SUBJECT: Triangle Expressway Southeast Extension (Complete 540) from NC 55 Bypass in Apex to US 64/264 (I-87) in Knightdale, Wake and Johnston Counties; Federal Aid No. STP-0540(19), STP-0540(20), and STP-0540(21); WBS Nos. 37673.1.TA1, 35516.1.TA1, and 35517.1.TA1; STIP Project Nos. R-2721, R-2828, and R-2829

From: [Williams, Andrew E CIV USARMY CESAW \(USA\)](#)
To: [Riffey, Deanna](#)
Cc: [Matthews, Monte K CIV USARMY CESAW \(USA\)](#); [Ridings, Rob](#); [Williams, Andrew E CIV USARMY CESAW \(USA\)](#)
Subject: [External] R-2721 B Modification (Mod8)
Date: Friday, July 1, 2022 10:26:47 AM
Attachments: [R-2721B Individual Modification plansMOD8.pdf](#)

Subject: MODIFICATION of 401 Water Quality Certification Pursuant to Section 401 of the Federal Clean Water Act, NEUSE BUFFER RULES, and ISOLATED WETLANDS PERMIT Pursuant to IWGP100000 with ADDITIONAL CONDITIONS for Proposed construction of the Triangle Expressway Southeast Extension (NC 540) in Wake & Johnston Counties, Federal Aid Project No. STP-0540(19-21), State Project No. 37673.1.TA2, TIP Nos, R-2721, R-2828, & R-2829.
NCDWR Project No. 20181249 version 9

R-2721B Stream Impact Revision:

PERMIT DRAWING
SHEET 27A OF 69

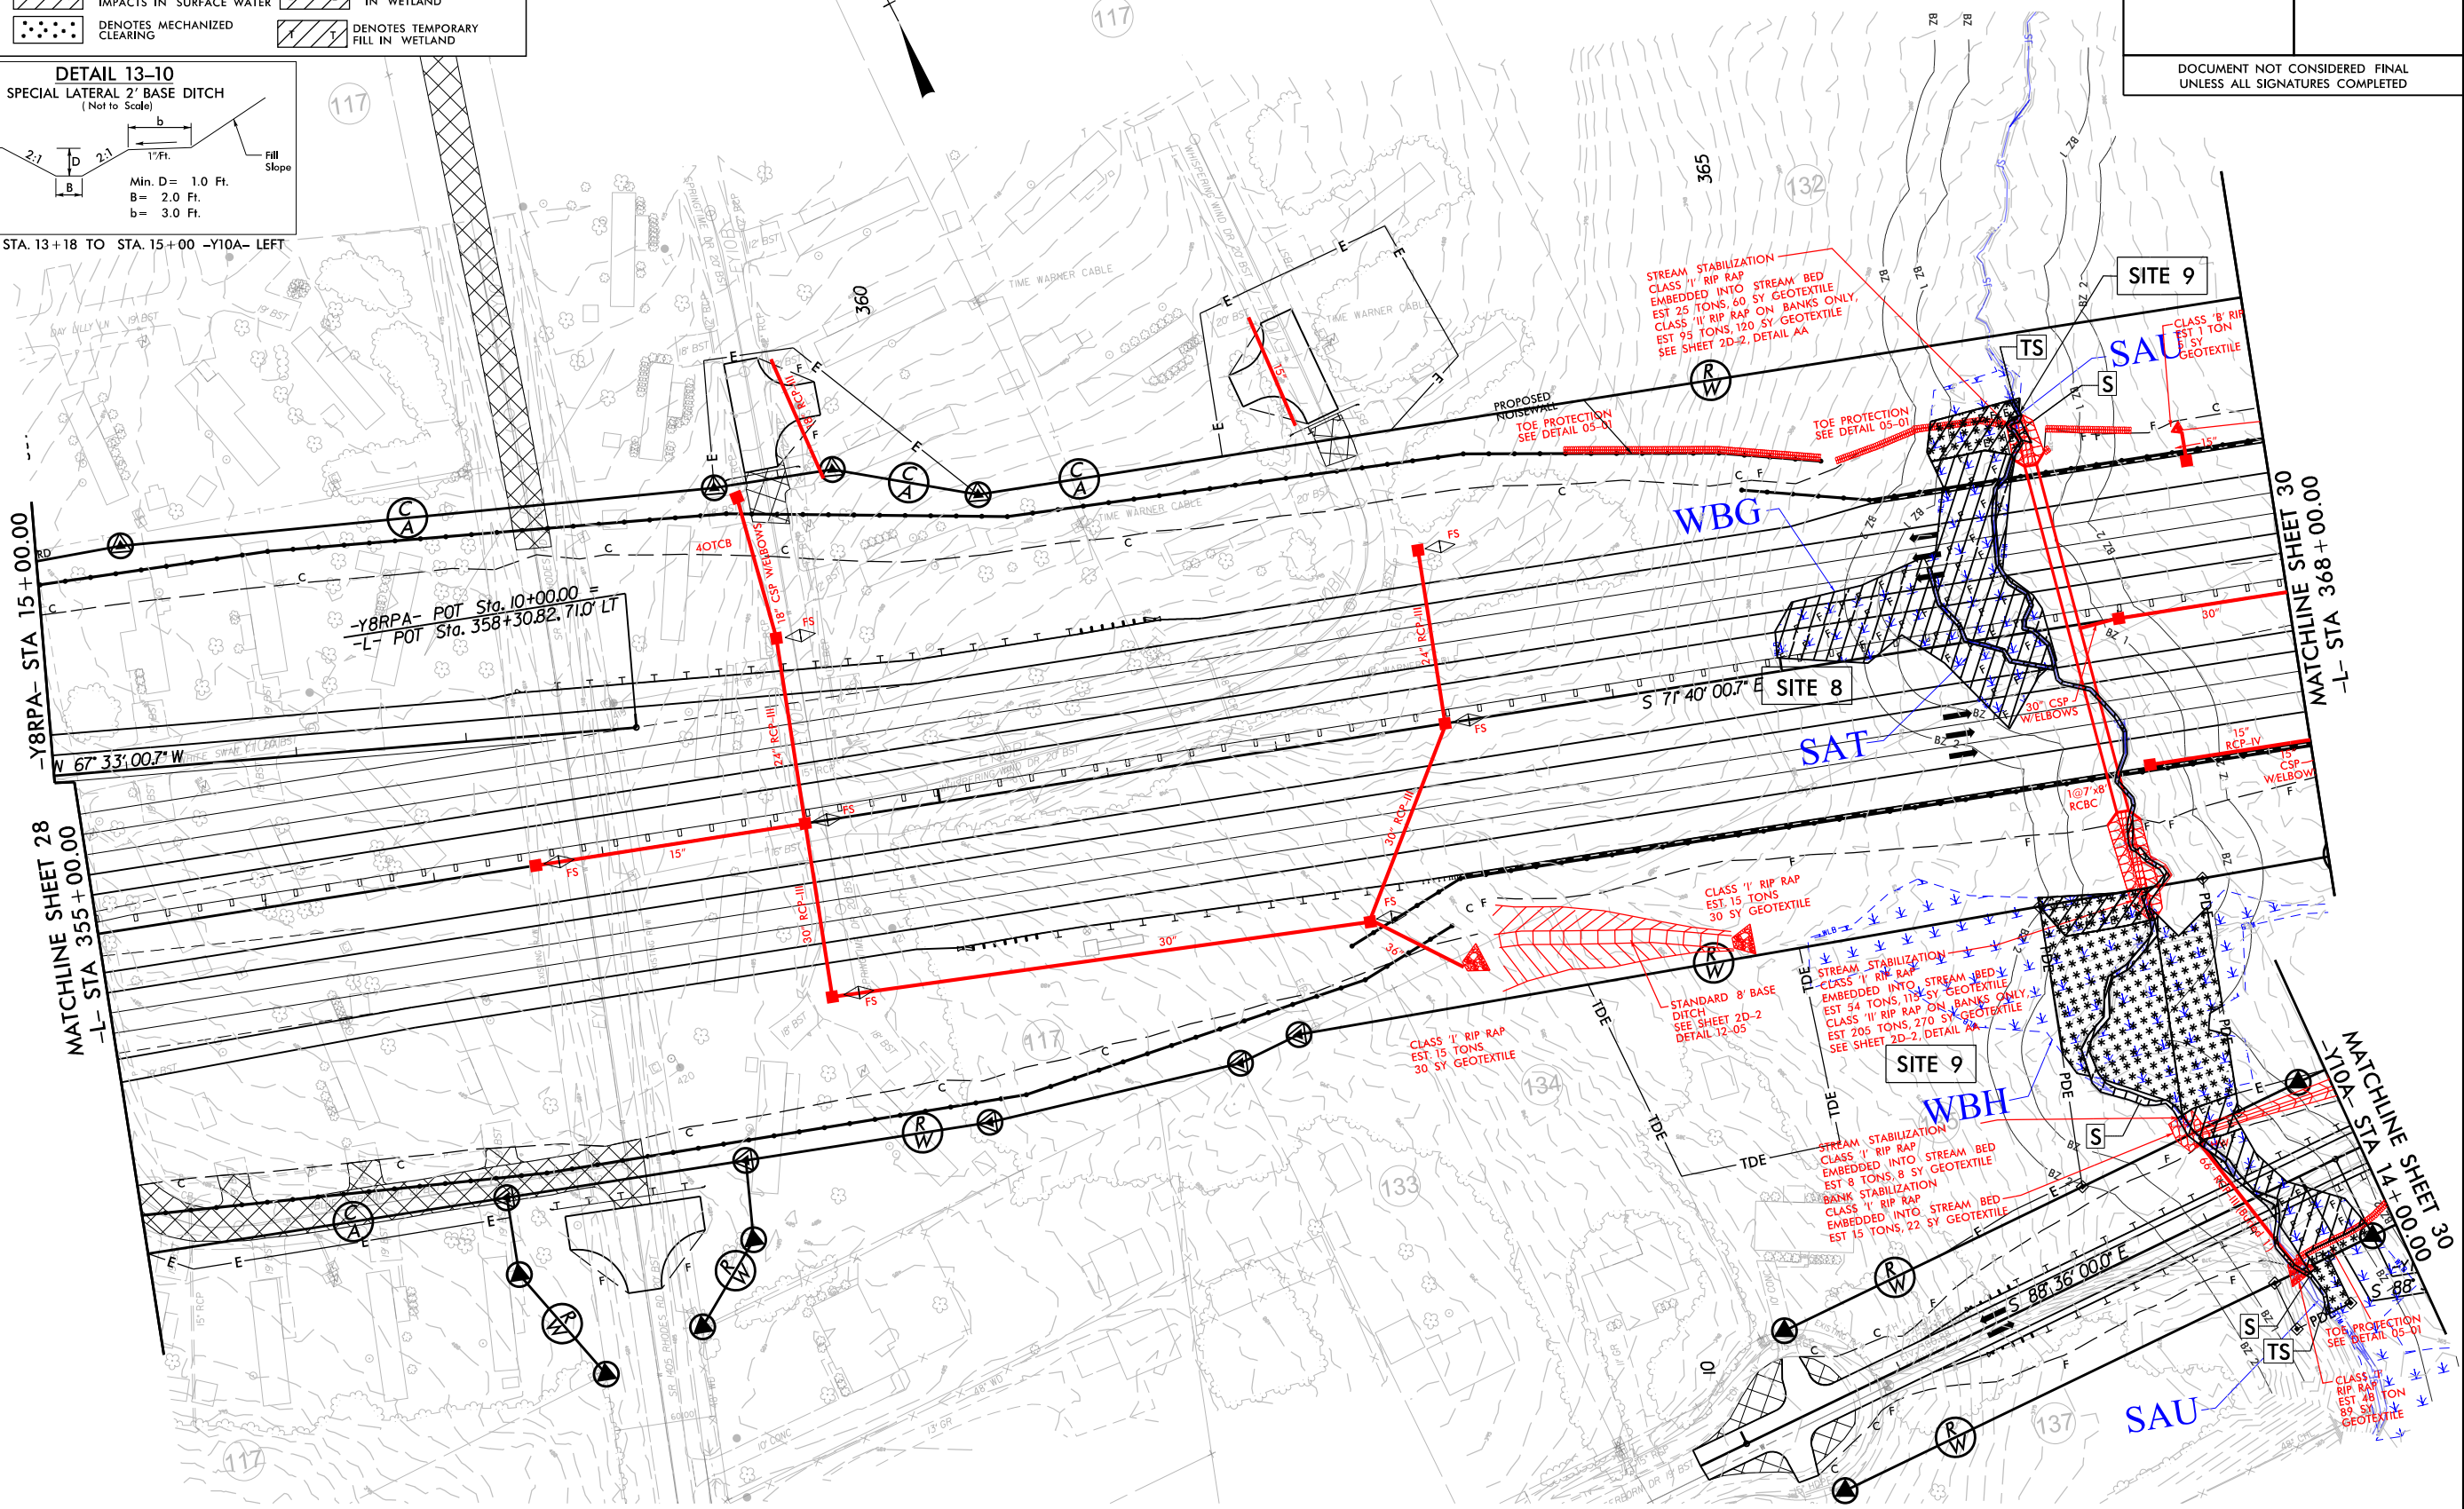
Specifically, an additional 0.054 acre of temporary excavation would occur at Permit Site 9. The total temporary excavation at that site is 0.06 acre. Additionally, at Permit Site 9, a temporary haul road would be constructed, impacting 0.07 acre of wetland. Permanent excavation at Permit Site 9 would increase from <0.01 acre to 0.07 acre. Stream bank stabilization activities at Site 9 are increased 20 linear feet from 115 linear feet to 135 linear feet.

Site 9: Additional 20 linear feet intermittent stream for streambank stabilization.

Revised Site 9 Total Impacts: 204 ft Permanent Fill. 135 ft Streambank Stabilization. 37 ft Temporary Impact.

Site 9: 0.054 acres Temporary Excavation changed from Mechanized Clearing.

0.07 acres Permanent Excavation changed from Mechanized Clearing.

Revised Site 9 Total Impacts: 0.06 ac Permanent Fill. 0.07 ac Permanent Excavation. 0.06 ac Temporary Excavation. 0.26 ac Mechanized Clearing.
